From: Martyn White
Sent: 23 November 2018 11:09
To: Planning.Responses
Cc: Simon Davis
Subject: AL/99/18/L

AL/99/18/L

The application seeks permission to carry out internal reconfiguration of the internal ground floor and 1st floor layout, reinstatement of a bricked up window on first floor, as well as for the replacement of three UPVC windows with ones of a traditional design.

Proposed West Elevation

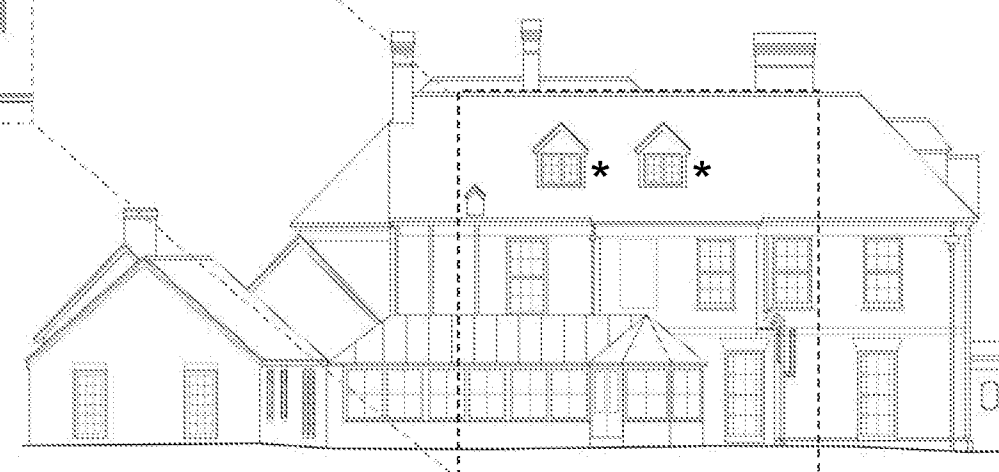
The reinstatement of a bricked up window on the first floor is supported as it would allow the western elevation to be returned to a more sympathetic appearance. Further it would allow the internal arrangement of the room affected by the works to be better appreciated. Further details of the window will be required in order to ensure that it closely reflects the neighbouring windows.
